Addendum No. 1

RE: Contract ID C202727

Beaufort County (B-4415)

Bridge Over Pungo Creek And Approaches On NC-32

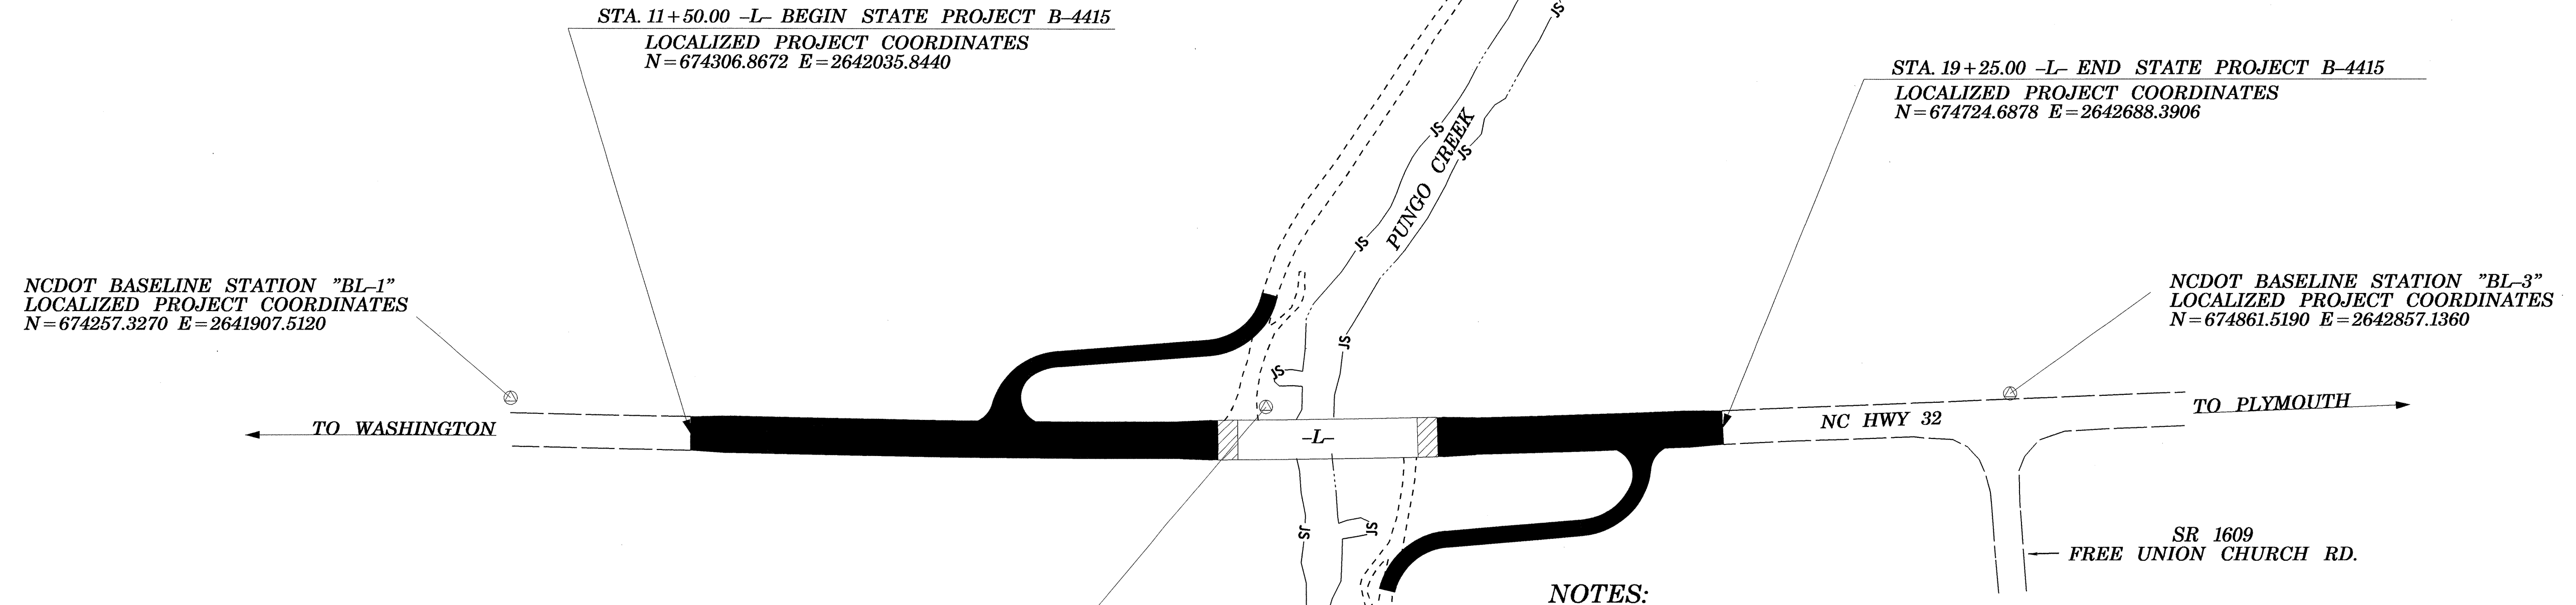
On Sheet No. 1-C some of the survey control information has been revised. Please void Sheet No. 1-C in your plans and staple the revised Sheet No. 1-C thereto.
